Your Ref: OWPC22322
Our Ref: BR/76/19/PL 11-03-2019
Please ask for:
Stuart Corbey

Conversion of existing house into 2 No. 3 bed semi detached properties.
Alloways 33 Shelley Road Bognor Regis

Thank you for your internet representation made on 24th April 2019 which has been recorded as '**an objection**' with the comments as follows:

Proposed Conversion Proposed Plans Planning
Date March 2019
Scale 1:50

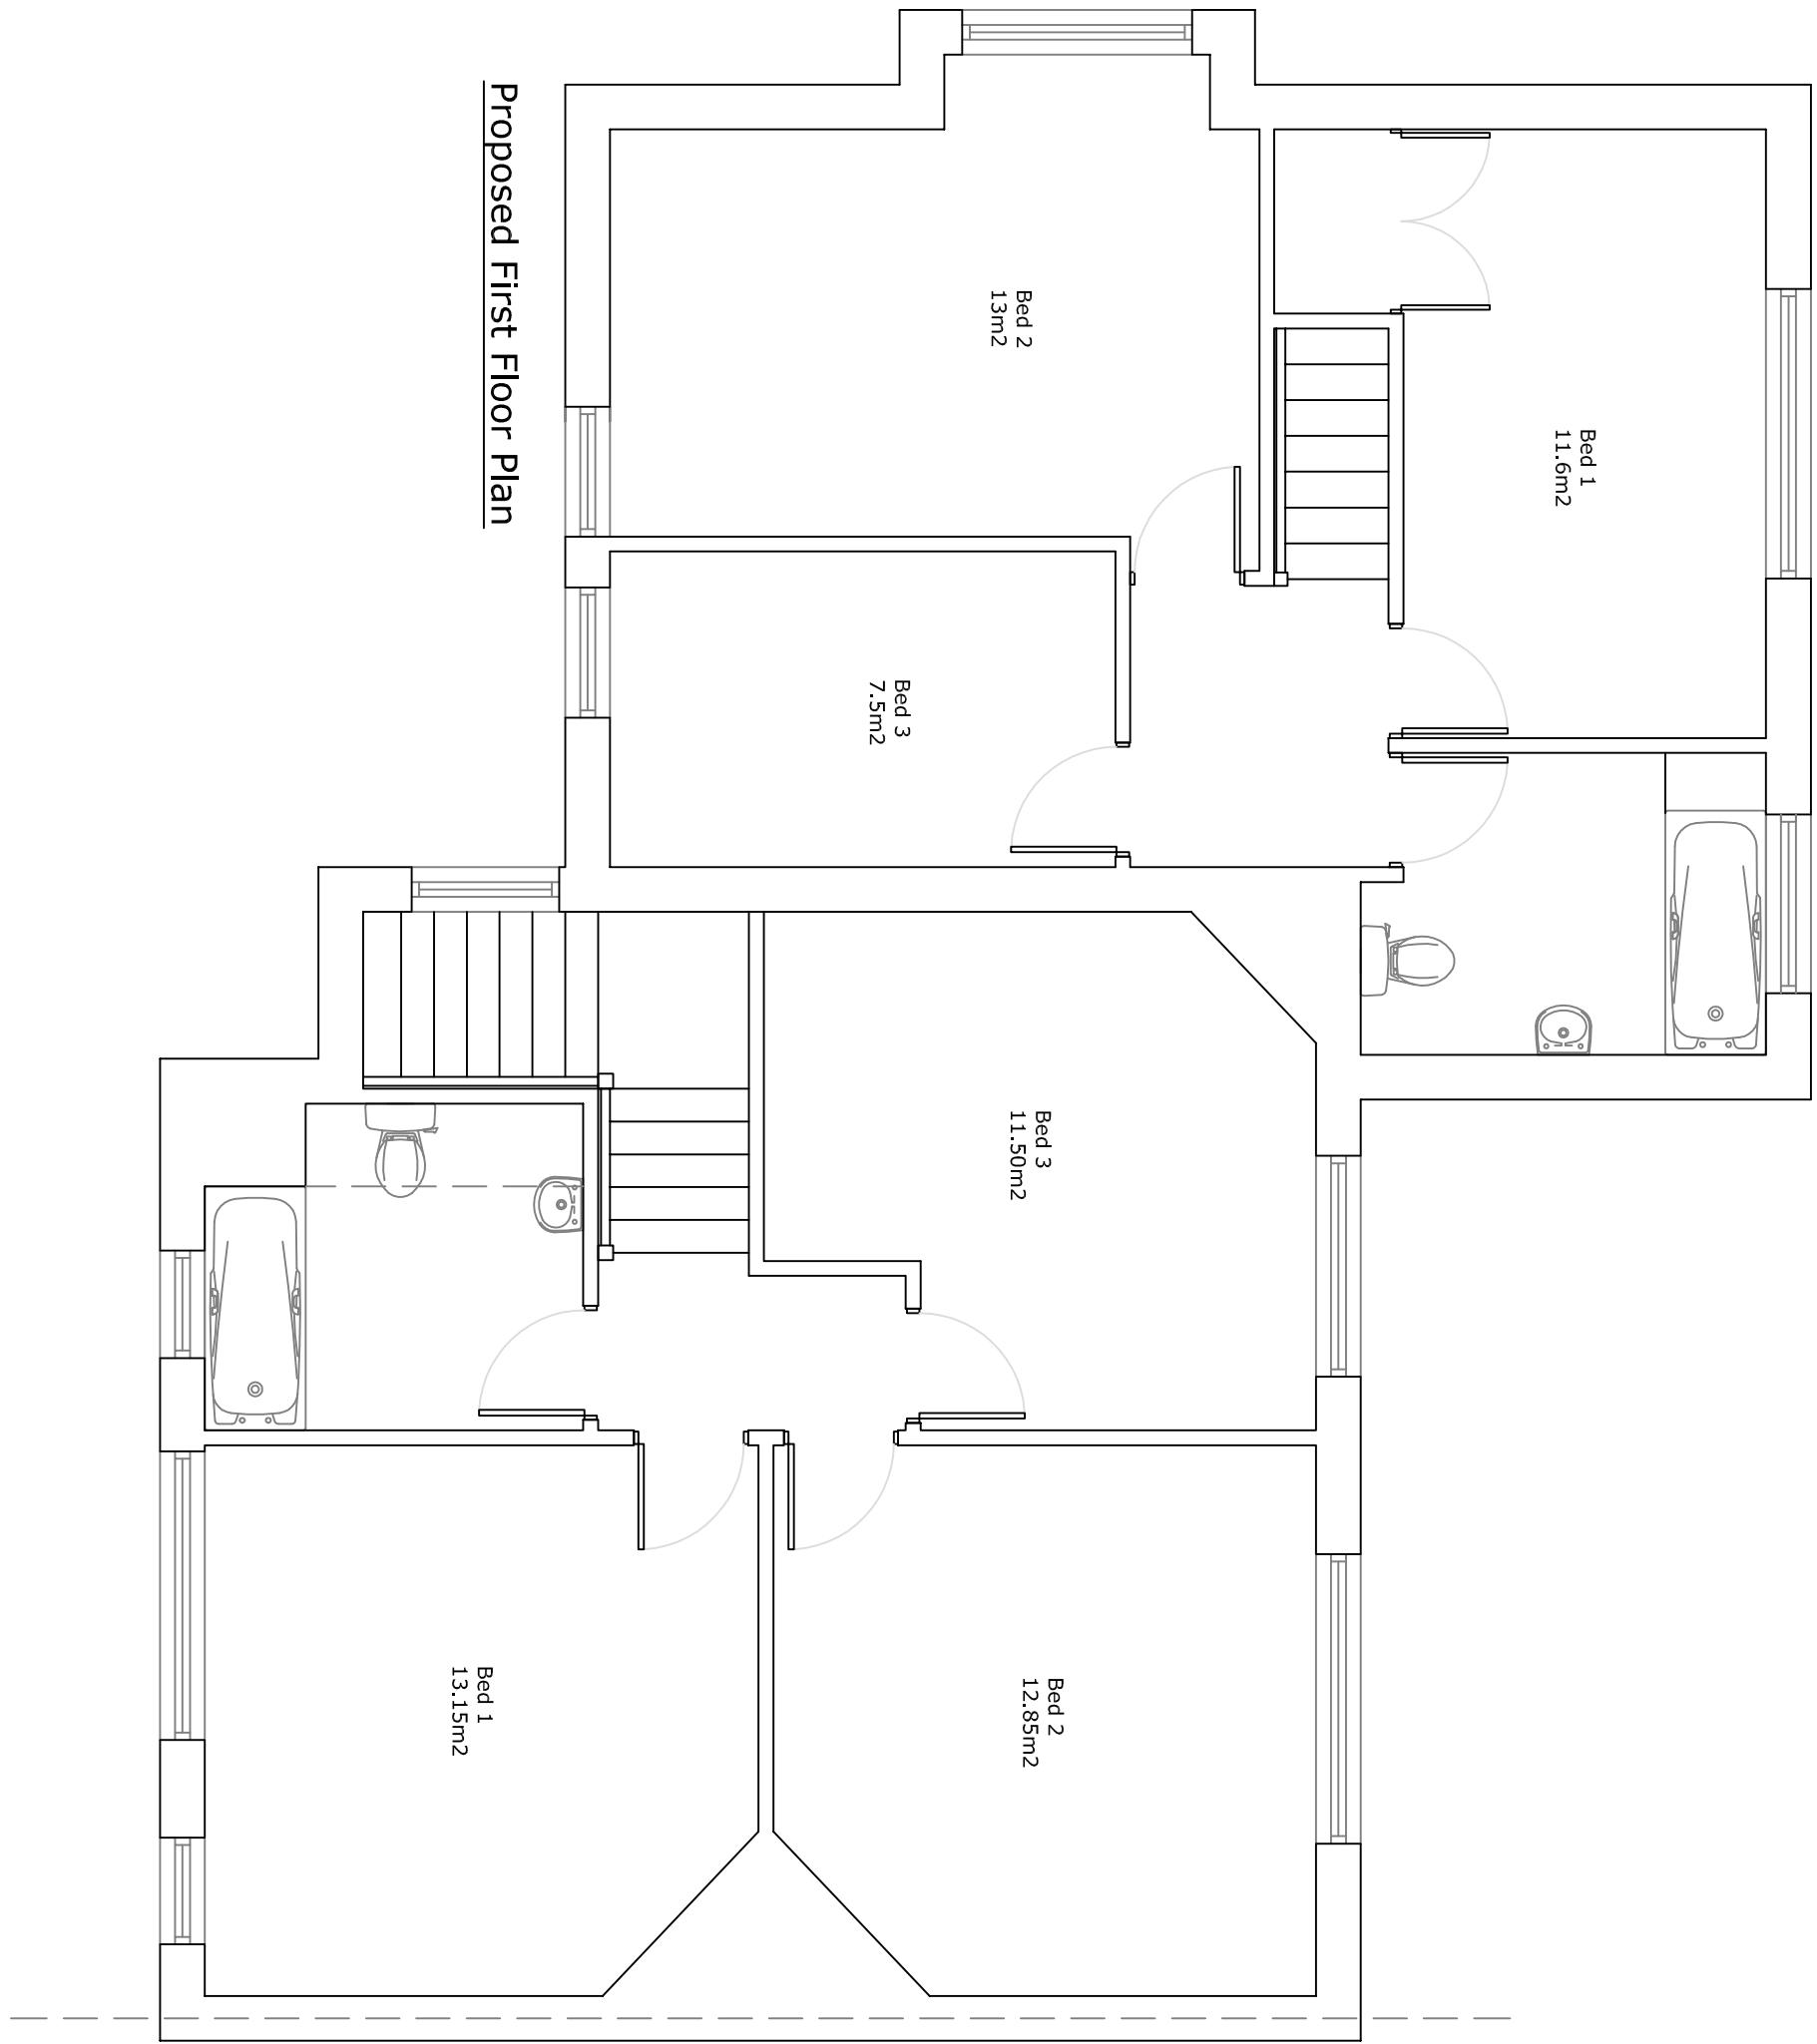
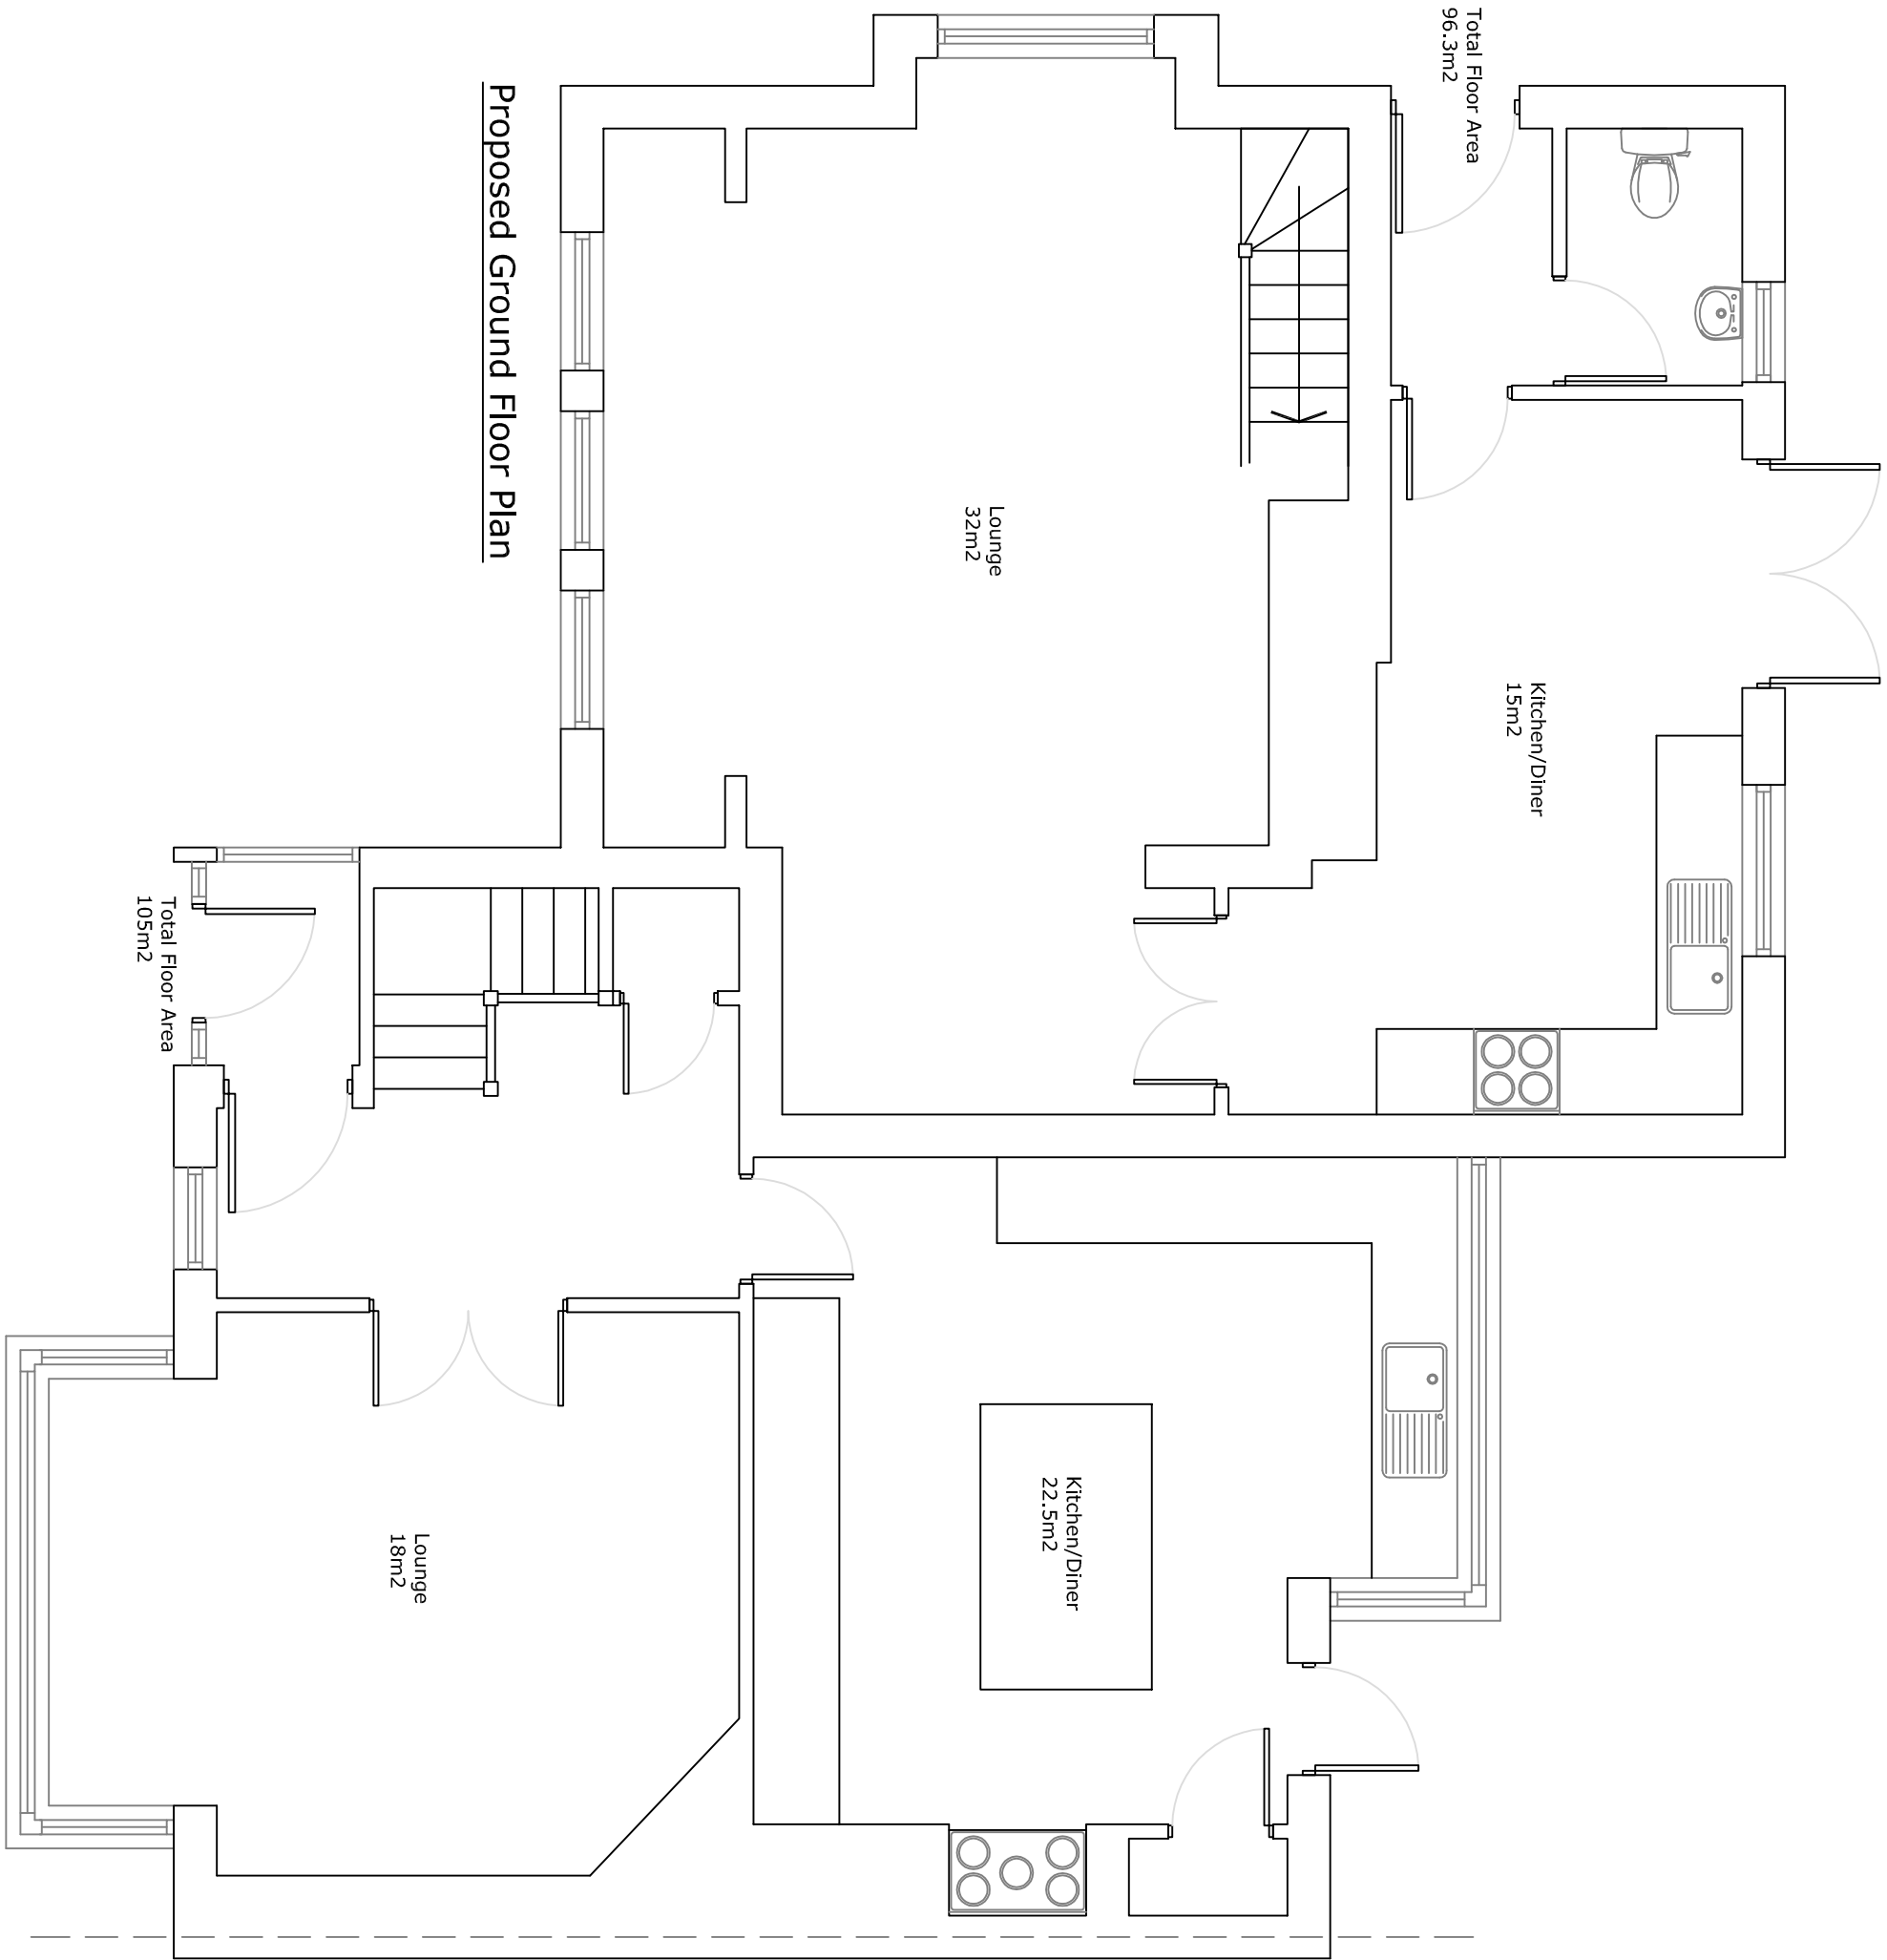
I am concerned that the parking will become worse than it already is if the house is converted into two properties. Parking is already bad and the turning from Shelley Road to Elm Grove is becoming dangerous. I suspect there will be an accident if more cars park in this area.

I have viewed the plans and am concerned that the bay window at the front of the property will be removed to make room for cars to park at the front of the property. This destroys the facade of the house and ruins the character of the property. If the bay window is not removed the cars will not fit on the front of the property meaning they will have to be parked on the street creating worse parking conditions.
